RE: DOCK & COOLER ADDITION FOR BORDEN, INC. (J-14/D47)  
DRAINAGE PLAN RECEIVED MARCH 1, 1985

Re: Drainage Plan for Borden,  
Inc. Dock and Cooler Add'n.  
(J-14/D47)  
BEI #6014-249

RE: DOCK & COOLER ADDITION FOR THE BORDEN COMPANY (J-14/D47)

SITE PLAN
 SCALE: 1" = 20'

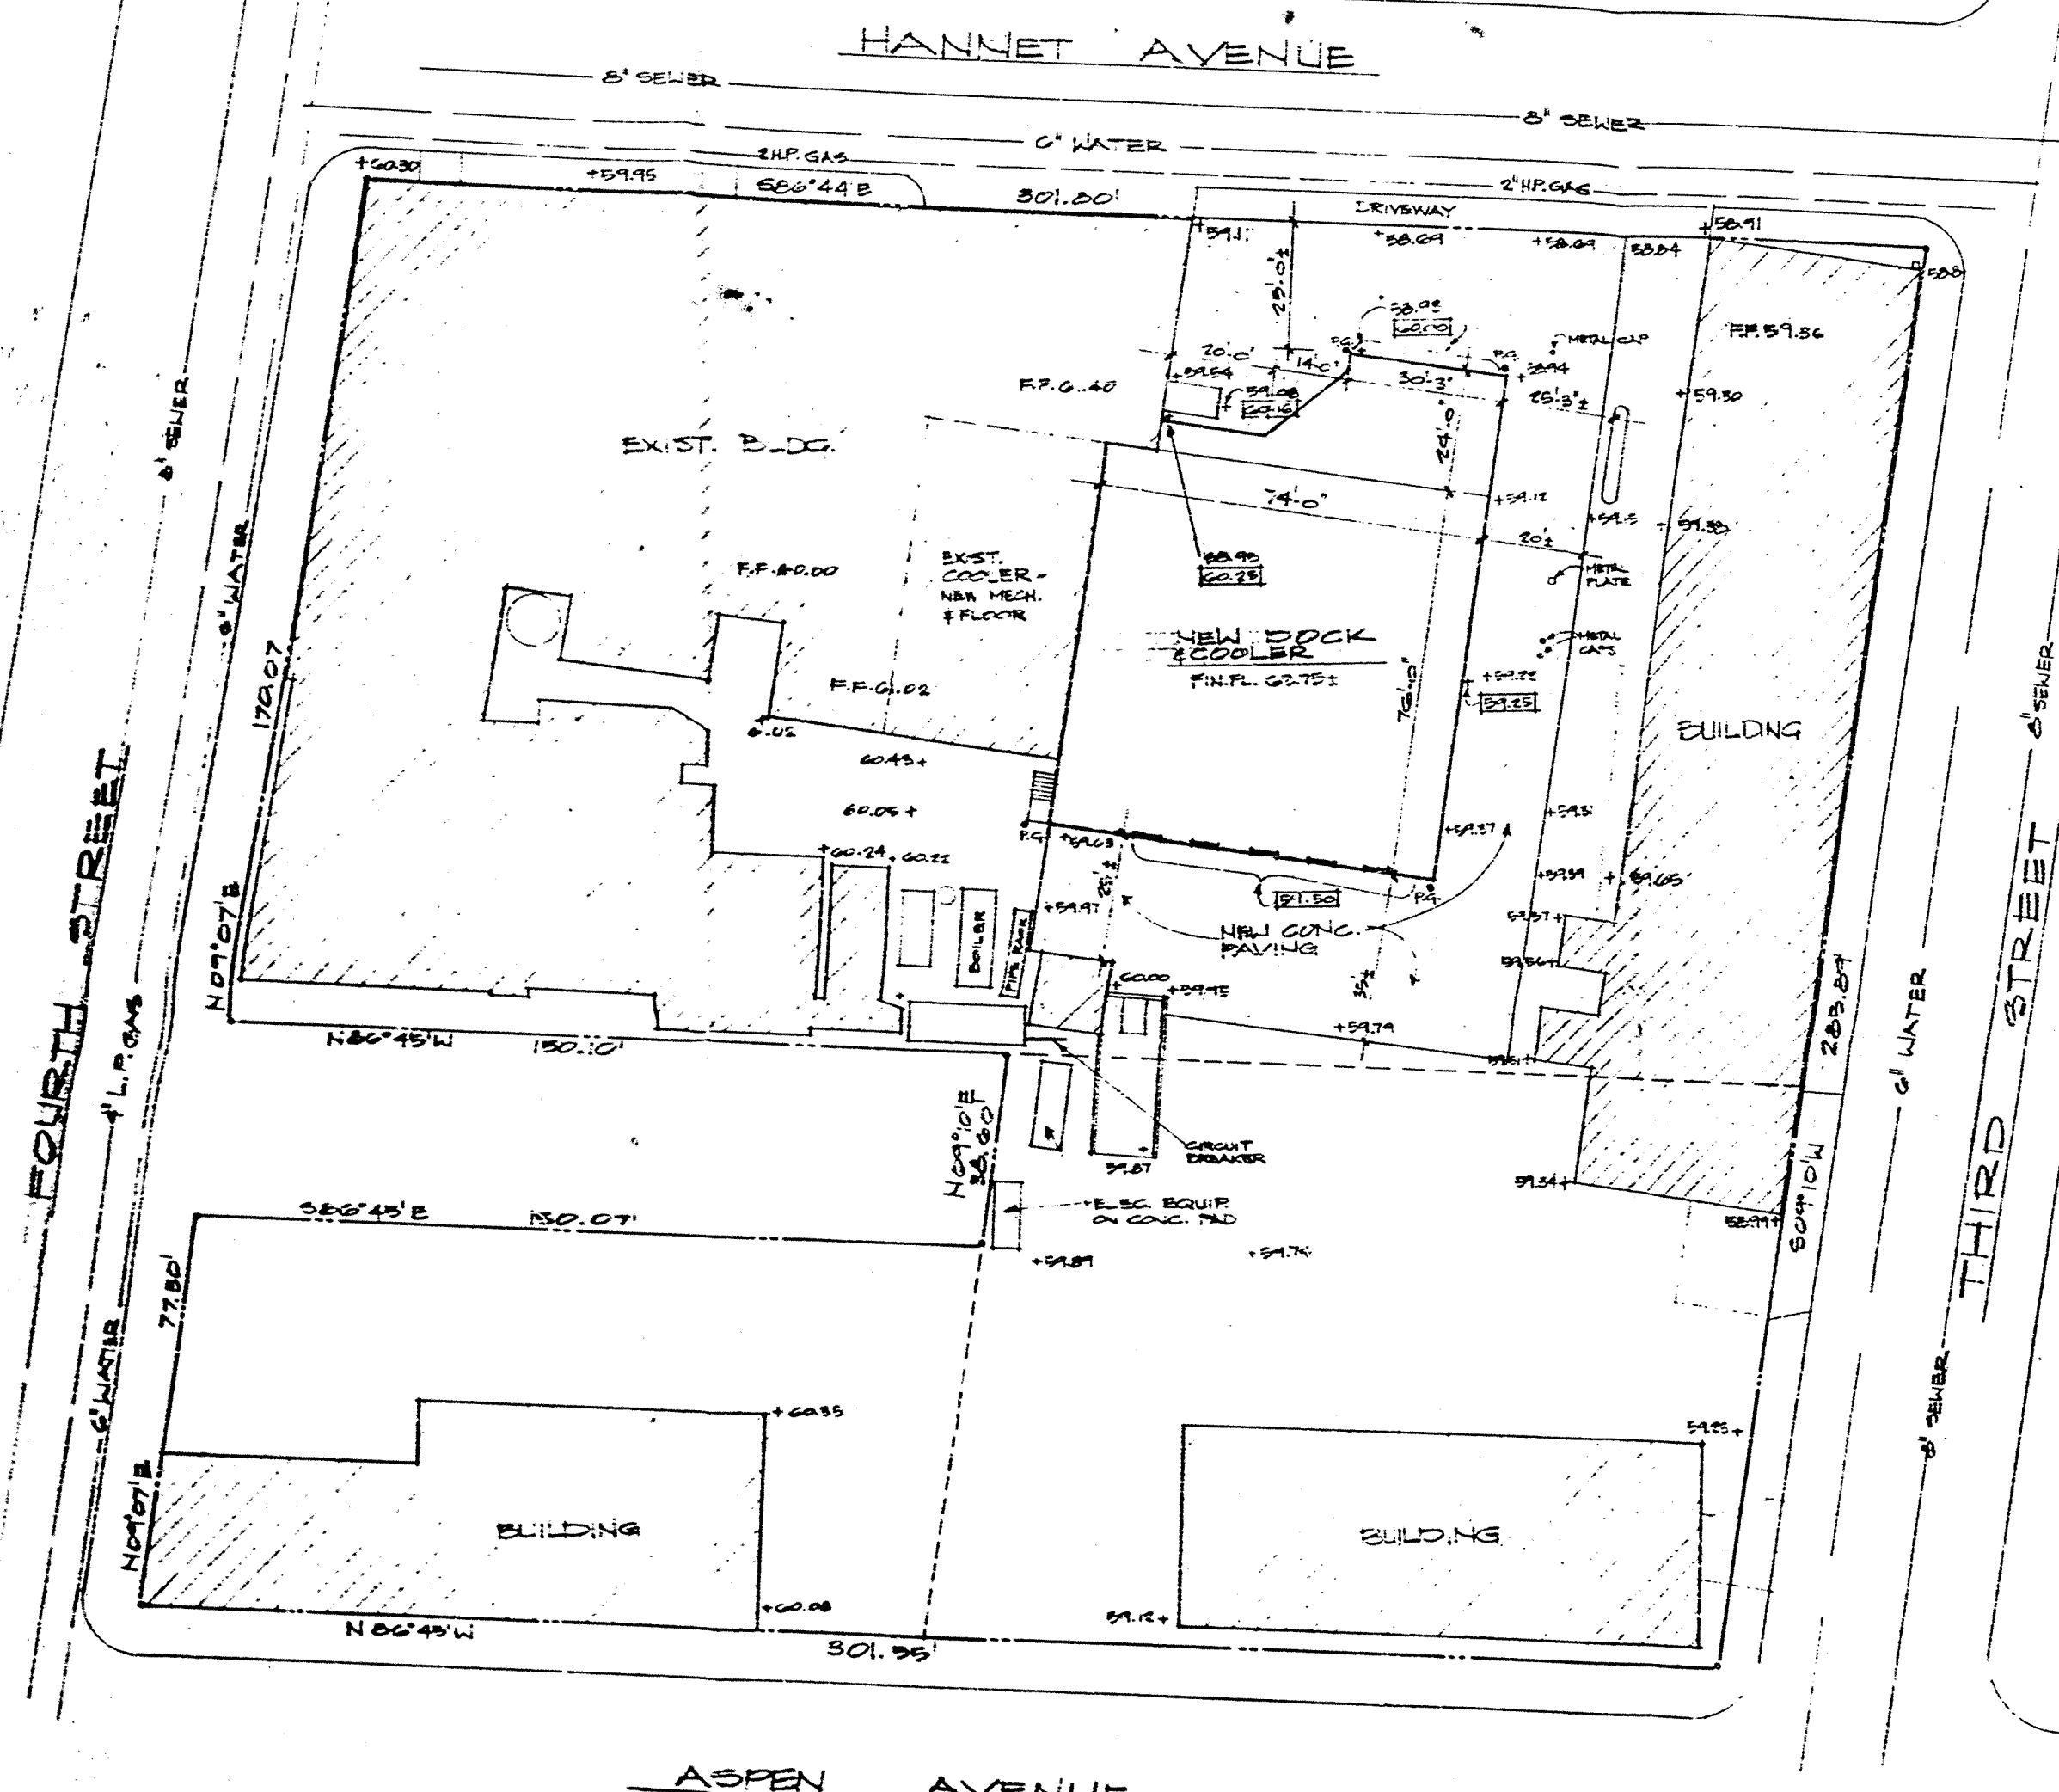
Based on the information provided on your January 28, 1985 submittal, listed are certain items that will need to be addressed before final approval is given:

1. New information sheet with resubmittal designation.
2. Plan must be prepared, stamped, signed and dated by a New Mexico registered engineer.
3. Flow volumes and rates - calculations showing on-site undeveloped and developed flow volumes and rates.
4. Vicinity map showing location of development in relation to well known landmarks, municipal boundaries and zone atlas map index number.
5. Benchmarks - location, description and elevation of the:
  - a. Albuquerque Control Survey Vertical Datum
  - b. Temporary benchmark on-site
6. Location and direction of roof drains.
7. Proposed treatment of developed runoff.
8. Top of curb and flow line spot elevations along bordering streets.

9. Legend - See DPM, Vol. 2, tables 27.3a - 27.3d for recommended standard symbols.
